Re: 71 Carleton Street – 055 C001 – R-6 – rebuild side entry porch – permit #2011-04-723

I have finished my review of your application to remove the existing side entry porch and replace it with a larger side entry porch at your property at 71 Carleton Street. At this point, I must deny your application.

# Main Deck Detail

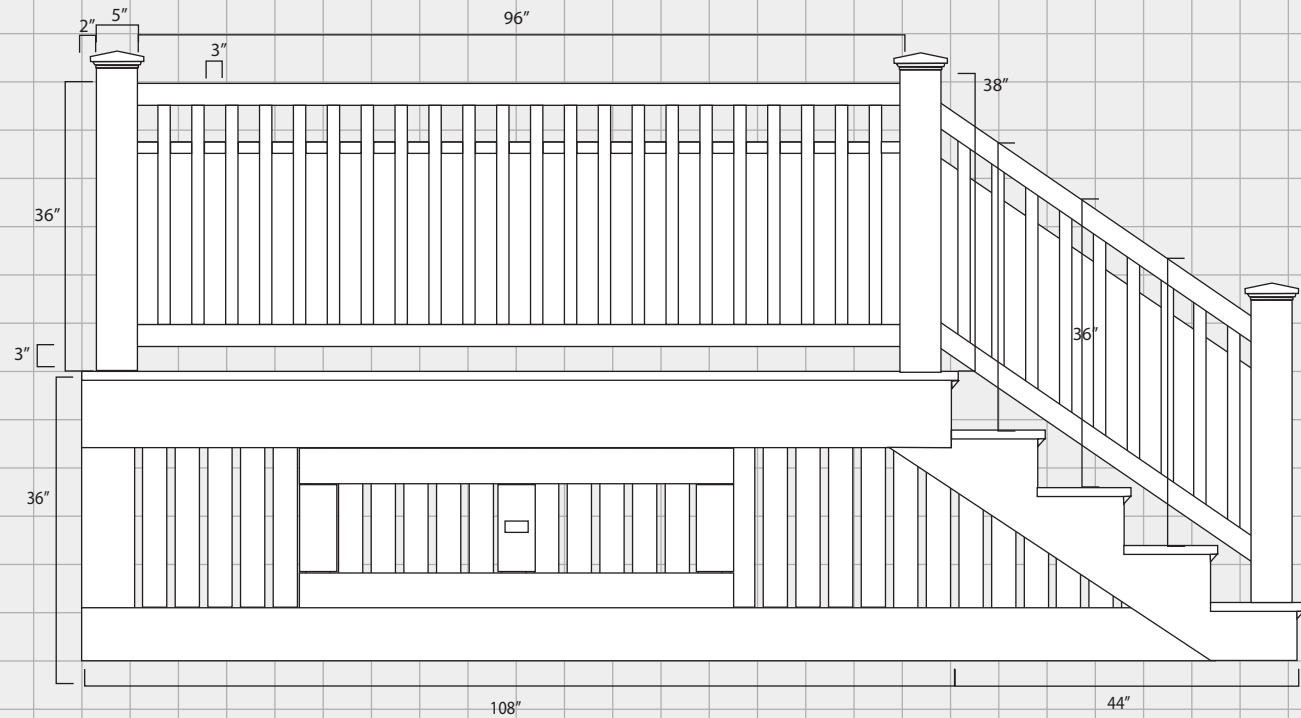
71 Carleton Street is located in the R-6 residential zone. The minimum required side setback is ten feet [section 14-139(1)(d)(3)]. The side setback to the existing entry porch is not given, but it appears to scale at around two feet. The side setback to the proposed entry porch appears to scale at about one foot. Since the existing entry porch is already nonconforming to the ten foot side setback, it cannot be made to be more nonconforming.

Section 14-139(1)(e) states that the maximum allowable lot coverage is fifty percent. Fifty percent of the lot is 975 square feet. The existing structure is legally nonconforming to the allowable lot coverage since it covers 1375 square feet of the lot which is 70.5 %. Scaling from the plot plan, the existing side entry porch is 3' x 8' (24 s.f.). The proposed side entry porch is 152" x 58.5" (61.75 s.f.). The proposed side entry porch would increase the size of the footprint and make the lot coverage more non conforming which is not allowed.
